2024/0860

Address: 12 Hall Gate, Penistone, Sheffield, S36 6BP

Description: Demolition of existing detached garage, and erection of single storey side extension incorporating new integral garage and additional habitable room in roof space to dwelling

Proposed Ground Floor

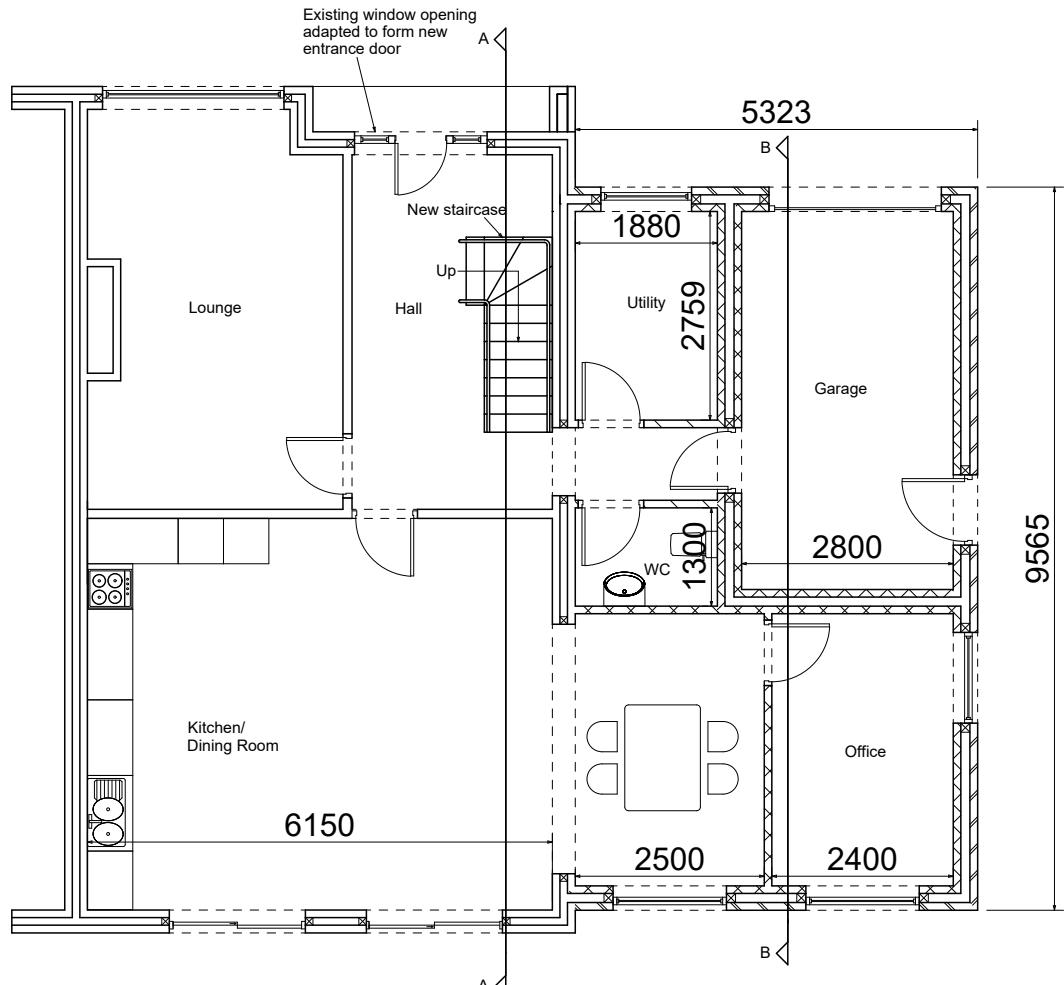
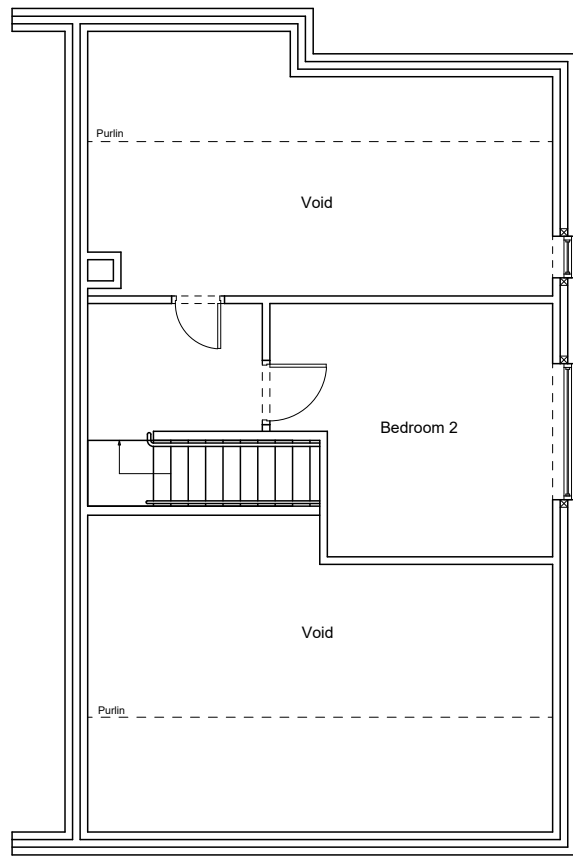
On this occasion, the width of the extension would extend the recommendation set out in the SPD House Extensions and Other Domestic Extensions, with the extension being more than two thirds the size of the original front elevation at 5.32m instead of the recommended size of 4.4m. Mitigation for this increase would be that the width of the proposal only marginally extends past the location of the detached garage it replaces, this realistic being no wider than the existing combined footprint of the existing dwelling and garage. Whilst it is noted that the length of the extension projects further into the front garden than the existing garage, the length has not increased from the approved proposal and parking provision for two cars on the driveway has remained. The proposed, previously approved and existing garage do not meet local policy sizing or positional standards to be considered as parking provision.

Proposed Front Elevation

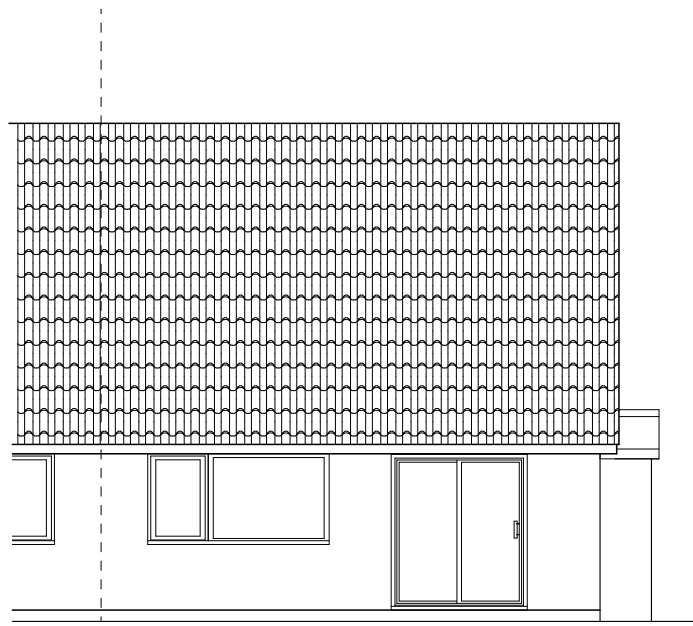
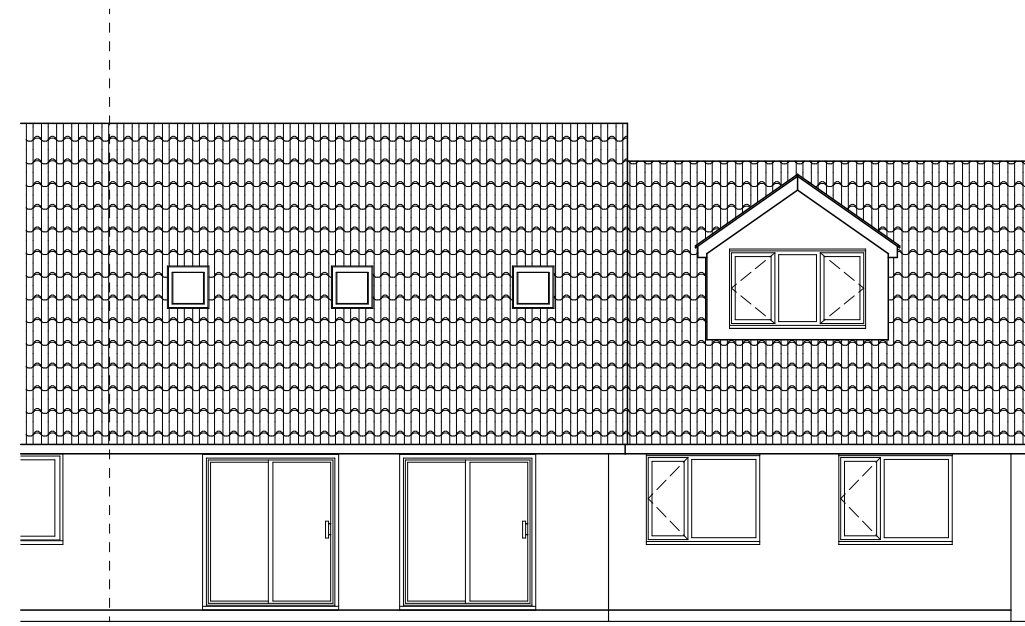
Two identical sized dormer windows are proposed to be installed within the roof space of the proposed extension, one at the front and one at the rear. The dormers are of a modest size and are of the design preferred in local policy, pitched roof instead of flat roofed. The extension is approximately just over 10m from the rear boundary, almost 20m from the commercial premises behind the dwelling, which the dormer would directly overlook, and over 25m, diagonally from the closest residential dwelling to the rear, which like all structures to the rear is at a higher elevation than the application dwelling. The front dormer is also over 25m from the closest residential dwelling (front elevation) of any dwelling it would directly overlook. Therefore the proposed dormer windows would have nothing more than an insignificant impact on the privacy of neighbouring dwellings and would meet local policy guidance for separation distance between windows (with the windows effectively being the same height as those on the first floor of a two-storey house).

The proposal complies with local policy guidance by including a setback of the proposed extension on the front elevation, a smaller setback on the rear elevation and the inclusion of a set down of the roof. Potentially the most prominent feature of the proposed works would be the front dormer windows and to a less extent the roof lights. Whilst dwellings in the street feature roof lights, and many feature large box or pitched roof dormers on the rear elevation, only No.4 features a front

dormer window, which like the proposal appears to be within the roof of a side dormer garage side extension. As such, the proposal would not create a precedent, and like No.5, it would not be expected to have any significant detriment to the street scene.

The front door is to be relocated to the front elevation, in the same manner as was approved within the application 2024/0142. Whilst this is a deviation from the street scene, it is compensated by an overall improvement to the character of the dwelling, given consideration of the proposed side extension. The proposed colour of the doors and windows have not confirmed by the applicant, but the agent has confirmed the dormers would feature a hanging tile to match the existing roof tiles would be used. With no distinct colour scheme to windows, doors or dormers within the street, on this occasion this would appear acceptable.
